MECKLENBURG COUNTY
Park and Recreation Department

MEMORANDUM

RE: Rezoning Petition #2022-187
PID# 19356102

**RZ-1.0**

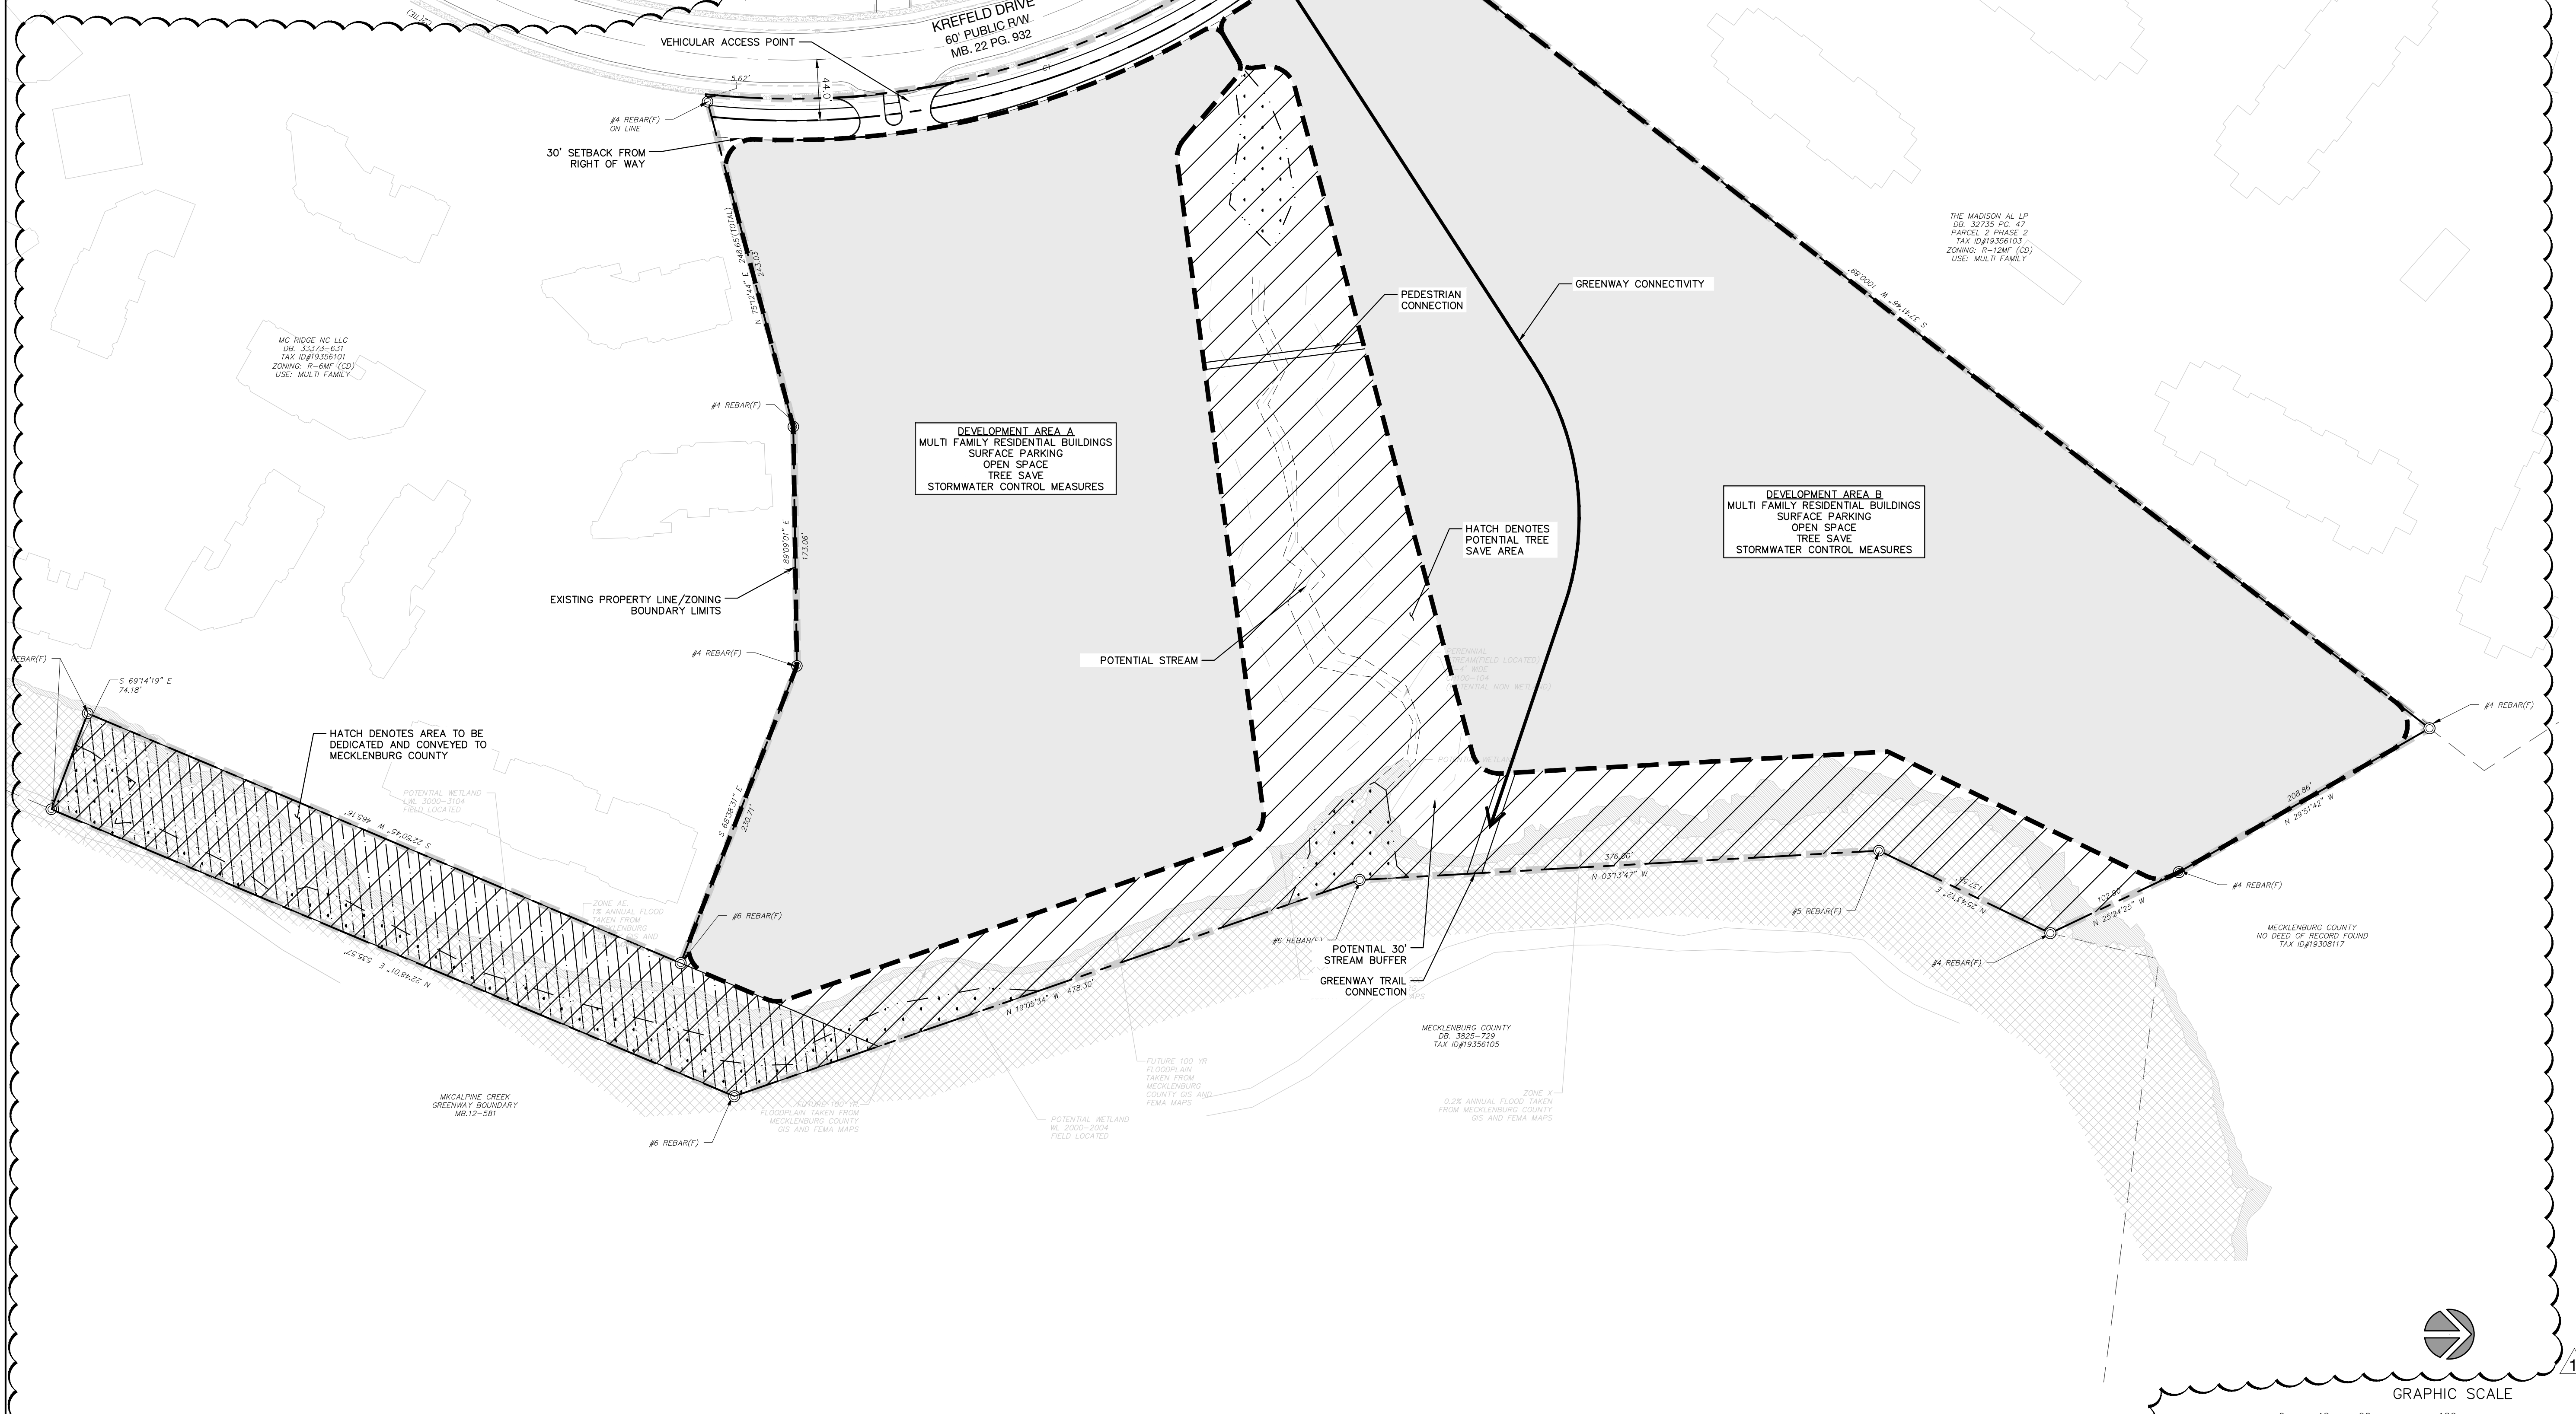
MCPR requests the dedication note be revised to be "dedicated and conveyed to Mecklenburg County", not Park and Recreation.
